From: Bloomer, David <David.Bloomer@lancashire.gov.uk>
Sent: 14 April 2016 10:57
To: Stephen Kilmartin
Cc: LHS Customer Service; planning; Lancaster, Jason
Subject: app3/2016/0193 Chipping Lane Longridge

Subject to the issues raised below being resolved to the satisfaction of the highway authority, I would; raise no objection to the proposal on highway grounds.

001 CHIPPING LANE
 LONGRIDGE
 Title
 PHASE 1 PLANNING LAYOUT

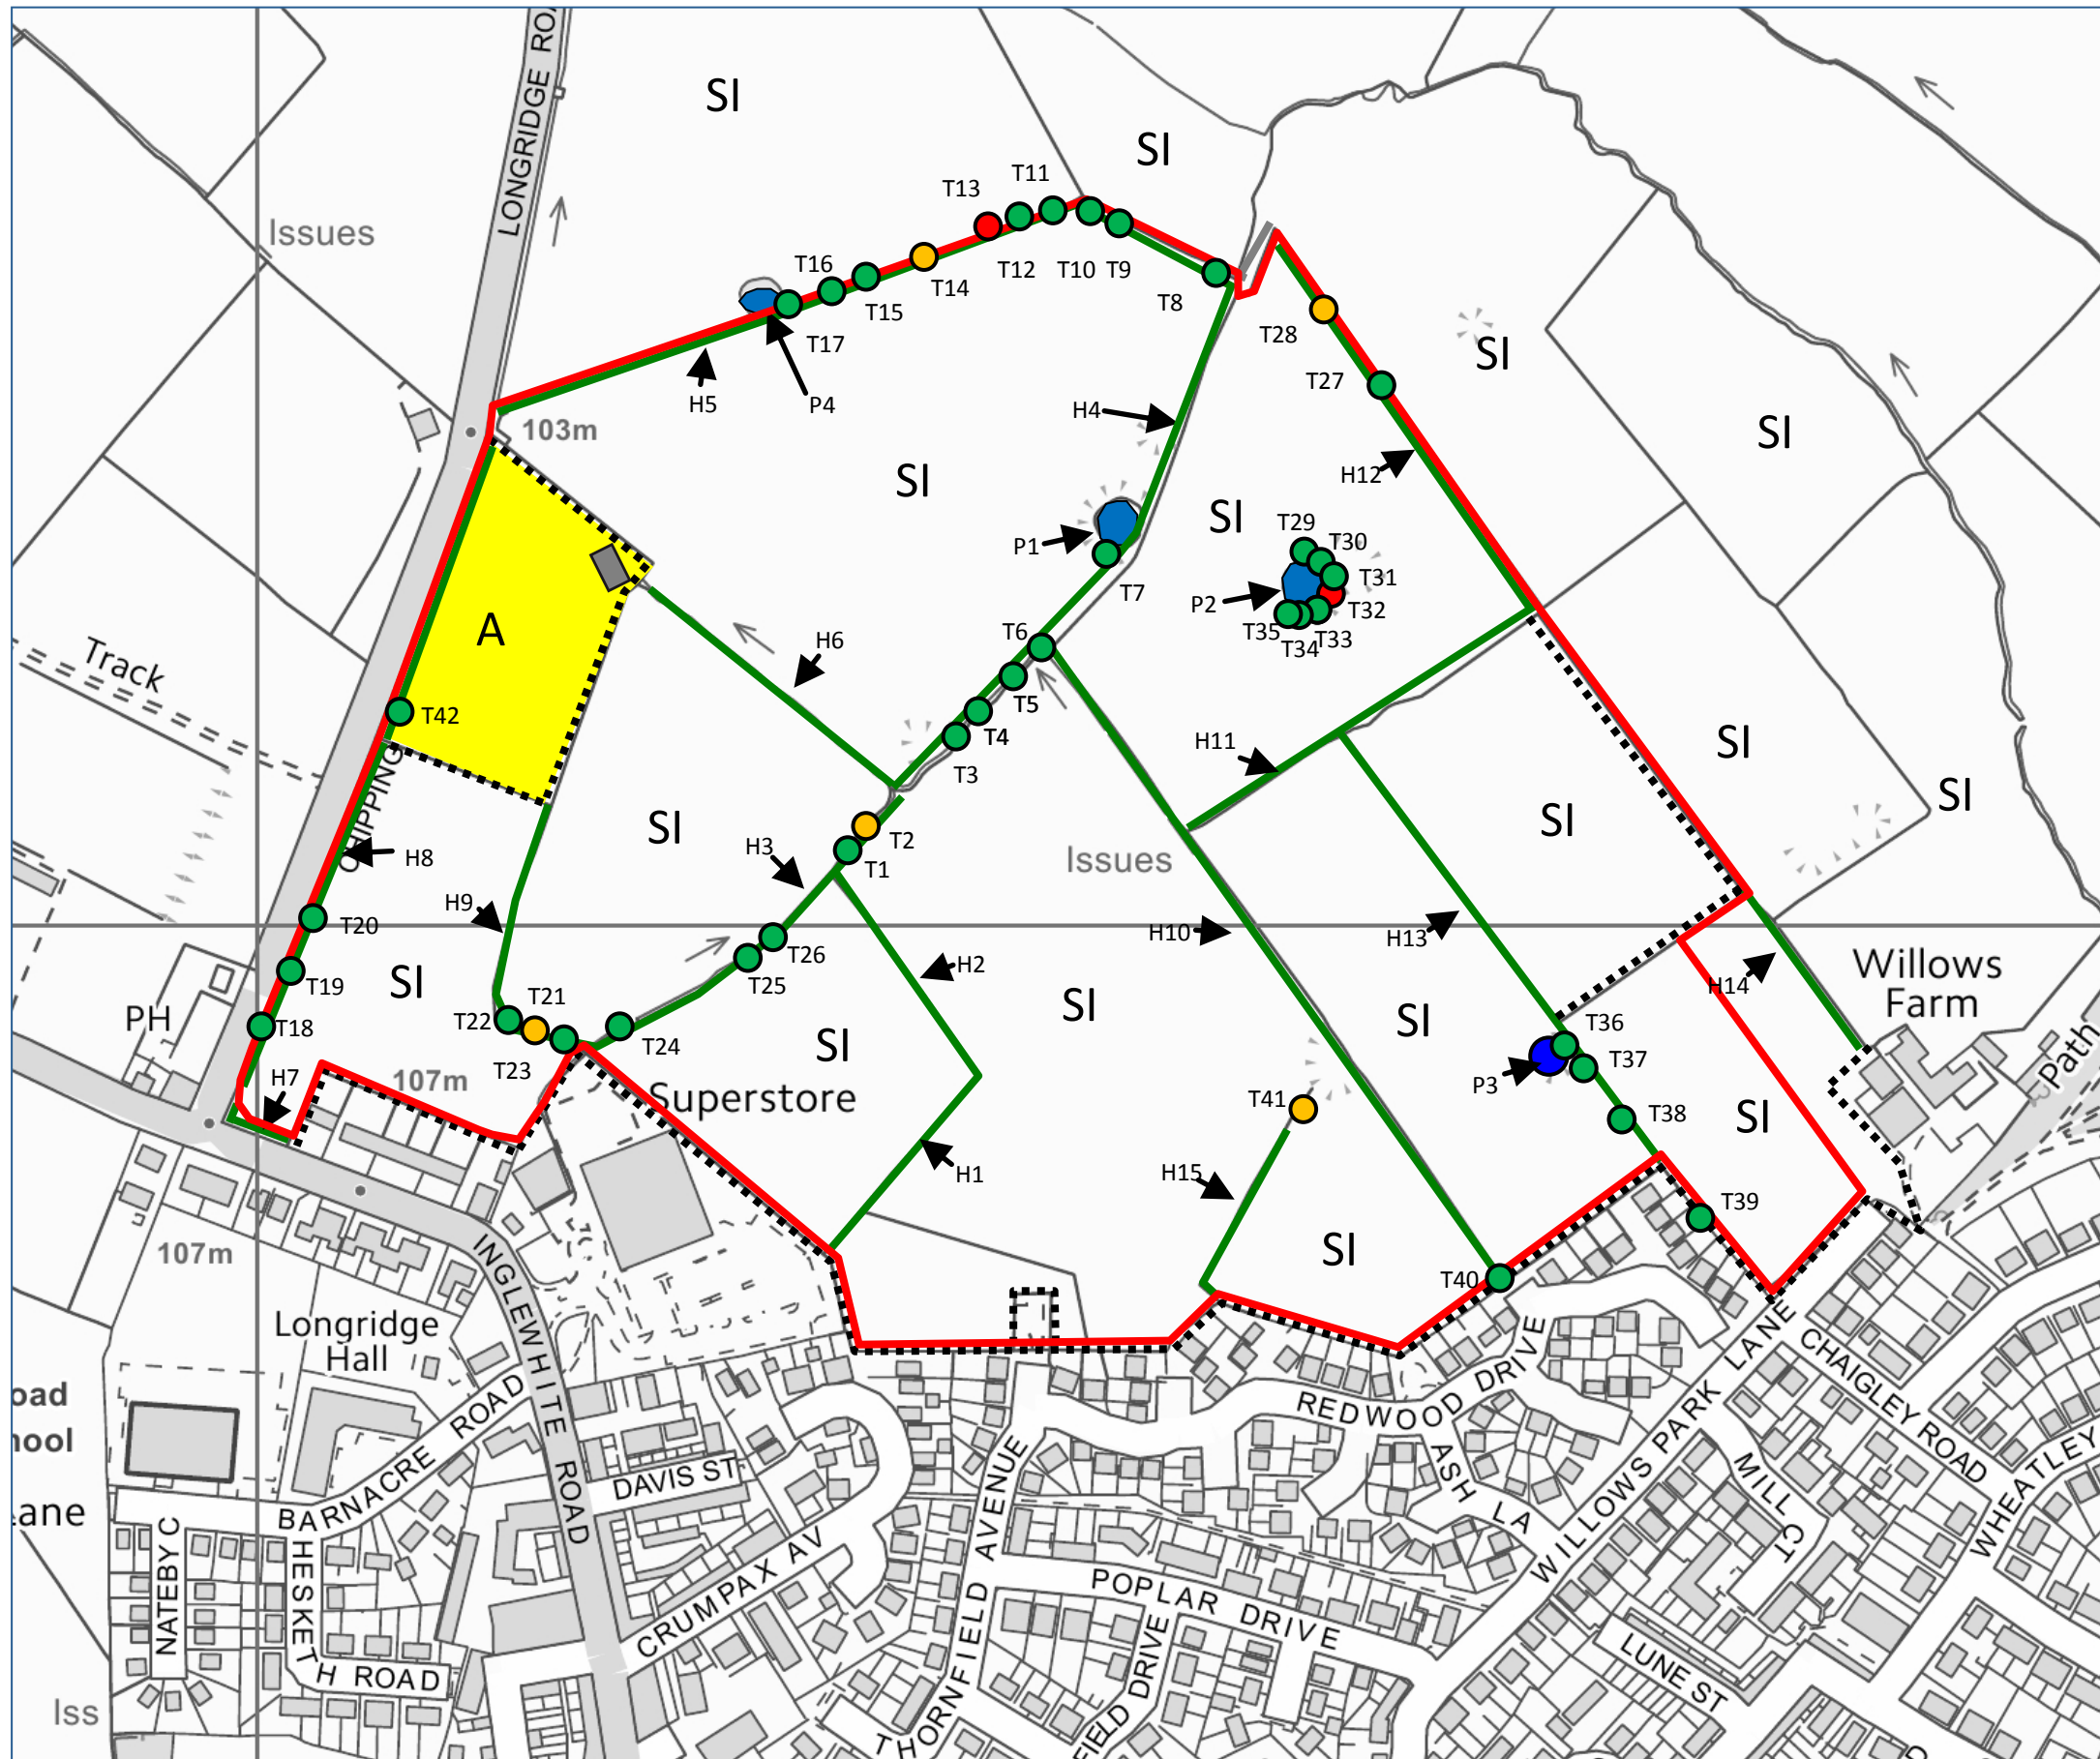
1 The semi-circular path at the site entrance onto Chipping Lane and the pedestrian /cycle links that run parallel and link into Chipping Lane would not be considered for adoption The highway authority would only consider adopting the carriageway and footway around the radius.

2 Assuming the "Pump Station" opposite Units 41 and 42 will require maintenance visits, it will need a dedicated parking space alongside. The layout plan shows a radiused kerb but unless there is internal parking available within the plot the parking space shown is too short and will obstruct the footway/ cycleway.

3 The line of the footway opposite units 43 – 46 should follow the carriageway to reduce maintenance liabilities to the highway authority.

4 Junction tables should be incorporated at the junctions located between units 50 / 68 and units 85 / 88 to maintain reduced vehicle speeds

5 A 2 metre service strip will be required fronting units 33 – 46

6 The access' to the parking areas for units 105 – 108 and 92 – 95 should be formed using kerbed radii and tactile paving

7 All pedestrian crossing points at junctions etc should use tactile paving

8 There should be a pedestrian/ cycle link between the site and Chipping Lane near to unit 20 (unless the paths referred to in Item 1 are retained on a " not for adoption " understanding)
